Rezoning Transportation Analysis

Petition Number: 2019-156

Reviewer: Eric Lemieux, PE
eric.lemieux@charlottenc.gov
704-336-2683

Date	Description
12-19-2019	First Review
02-18-2020	Second Review (WB)
05-14-2020	Third Review

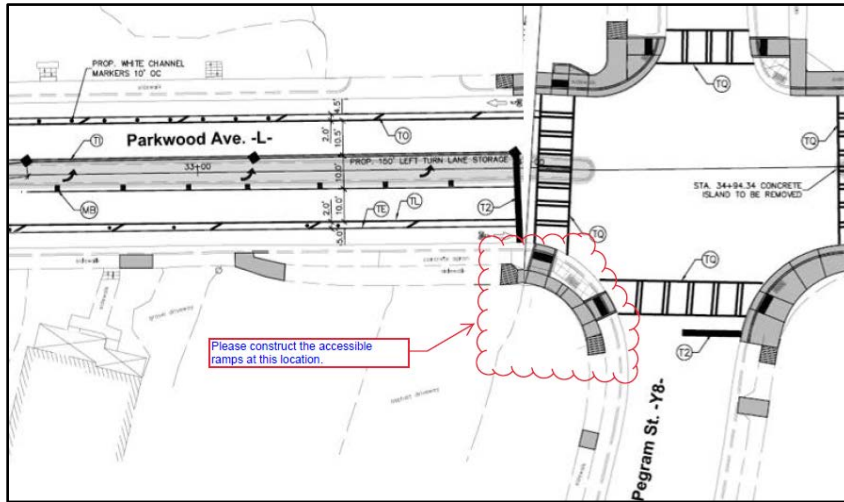
The site plan should show the curb and gutter labeled and dimensioned from the centerline for each road.
- ~~**Traffic Study**~~ A Traffic Impact Study is not necessary for the complete review of this petition.
- ~~The petitioner should revise the site plan and conditional note(s) to commit to construct two directional ramps at the intersection of Parkwood Avenue and Pegram Street, per the *Parkwood (N. Davidson – The Plaza) Improvements* construction plans. Please refer to these plans within the rezoning site plan and conditional note(s). The *Parkwood (N. Davidson – The Plaza)* plans are available upon request.~~

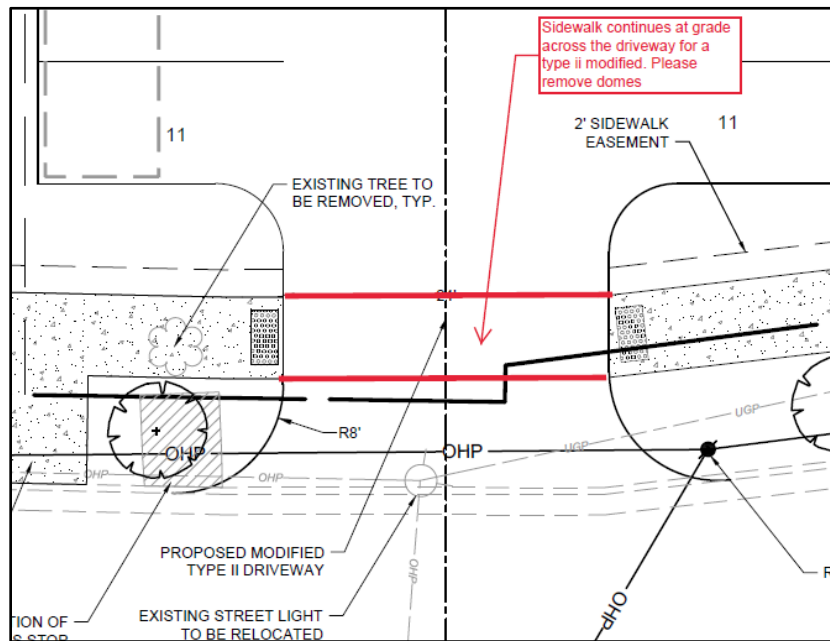
4. The petitioner should revise the site plan and conditional note(s) to remove the truncated domes and to continue the sidewalk at-grade across the driveway.

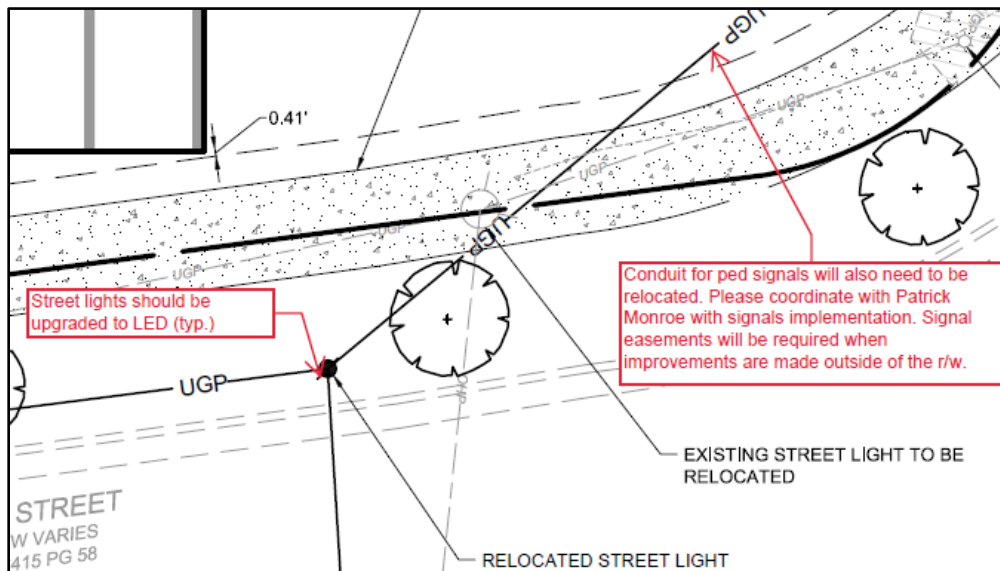
- The petitioner should revise the site plan and conditional note(s) to include utility easements where underground conduit is placed outside of the public r/w for the relocated street lights. The petitioner should commit to upgrading the street lighting along the site's right-of-way frontage to LED. Coordinate with Patrick Monroe (Patrick.Monroe@ci.charlotte.nc.us at 704-336-3937).
